From: Housing Manager DAU <Manager.DAU@npws.gov.ie>
Sent: Friday 10 April 2026 15:55
To: LAPS <laps@pleanala.ie>
Cc: SIDS <sids@pleanala.ie>
Subject: ACP-323950-25 Graiguenamnagh Tinnahinch Flood Relief Scheme

Our Ref: S177AE Graiguenamnagh Tinnahinch FRS

Re: Section 177AE application by Kilkenny County Council for Graiguenamnagh Tinnahinch Flood Relief Scheme

Observation on the Planning Submission, Cultural Heritage Chapter EIAR

DRAWING TITLE
FLOOD RELIEF WORKS
GRAIGUENAMANAGH QUAY
SECTIONS -- SHEET 2

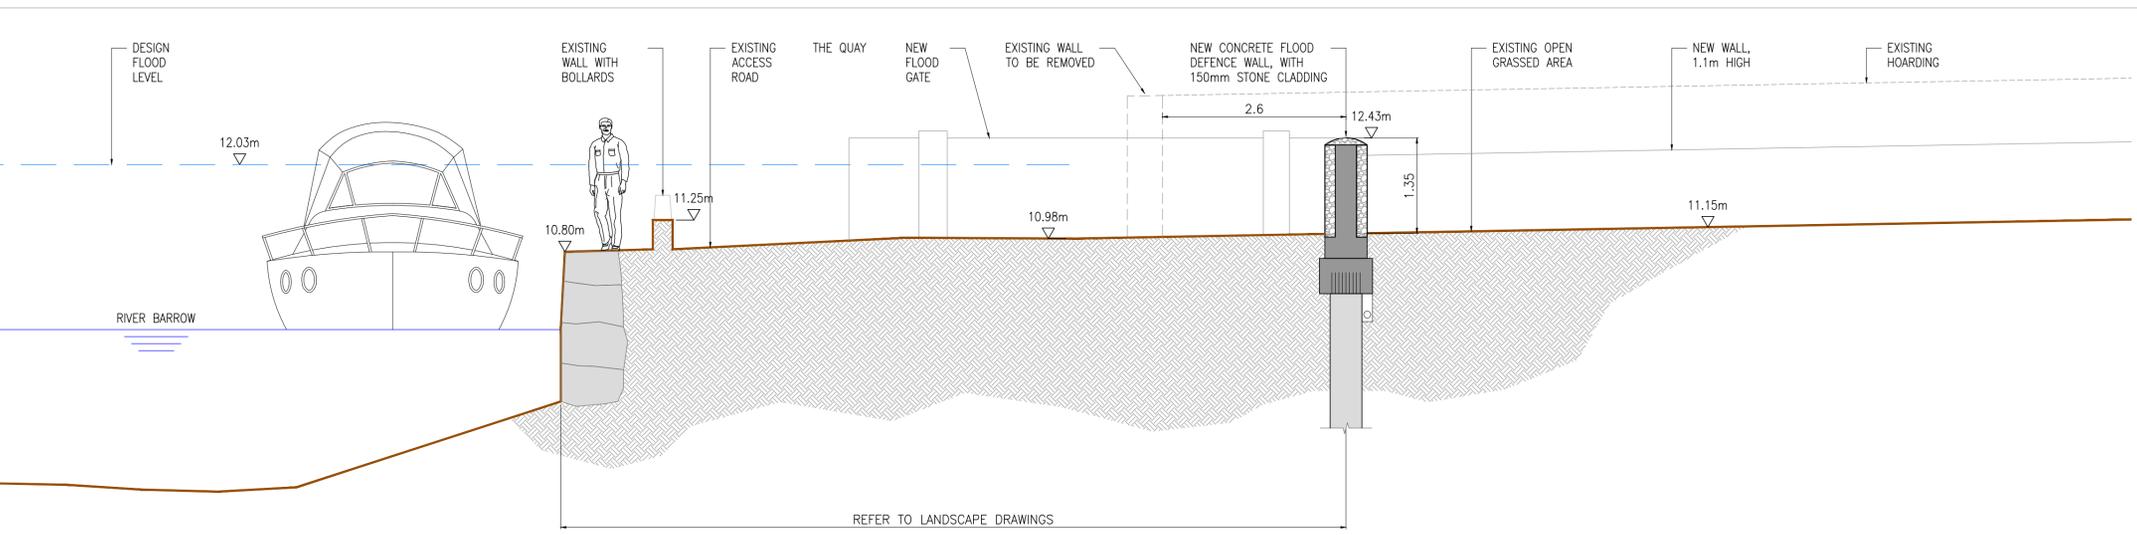
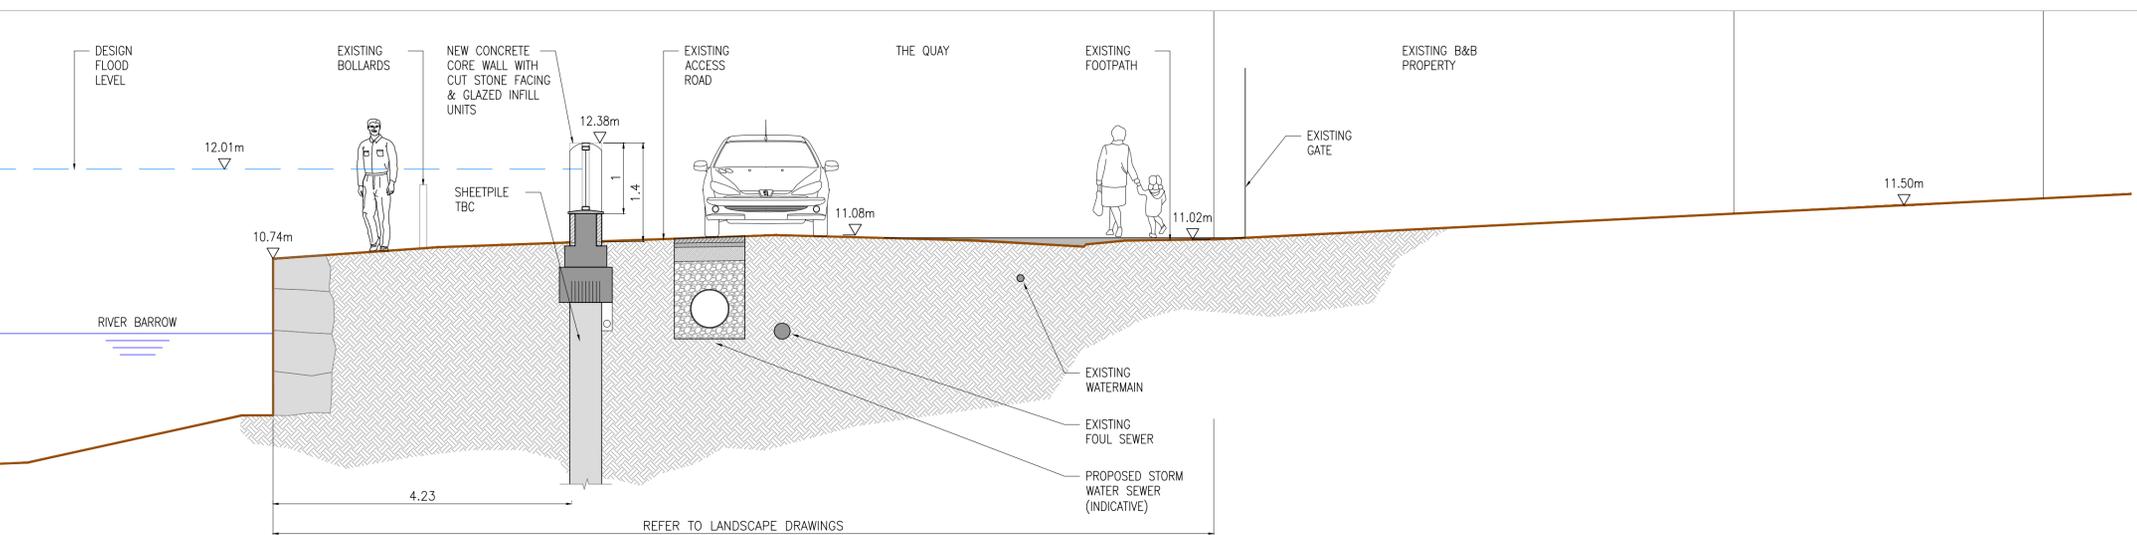
Appended to this report is the myriad of walls and new elements flood relief barriers proposed within the historic centre. Whilst it can be accepted that flood relief is of the utmost importance to the future sustainability of the town and that the areas identified for engineered intervention have been selected to avoid adverse archaeological impact, the level of detail provided by a stage 2 submission doesn't adequately deal with the coherence and overall design of the proposed flood relief barriers, the quality of materials and craftsmanship necessary to mitigate the scale of the flood relief barriers in this unique historic setting. The stage 2 scheme as presented proposes rudimentary concrete barriers in some instances, new areas of raised ground and unfortunately, quite extensive new masonry barriers for the full expanse of the

river front setting along. The stage 2 proposal omits architectural/conservation input as part of the multi-disciplinary practice in terms of guiding contemporary design, sustainability of materials, conservation upgrading, nature based solutions and quality outcomes, including coordination as necessary with new public realm, lighting etc. to unify and revitalise the character of the place – Graiguenamagh and Tinnahinch. Reference to Clonakilty 400, Phase 3 with OPW, the EU exemplar for community engagement, flood relief and public realm enhancement - featured in the OMC report European Commission 2021 - Towards a shared culture of architecture – investing in a high-quality living environment for everyone <https://op.europa.eu/en/publication-detail/-/publication/bd7cba7e-2680-11ec-bd8e01aa75ed71a1/language-en/format-PDF/source-search>
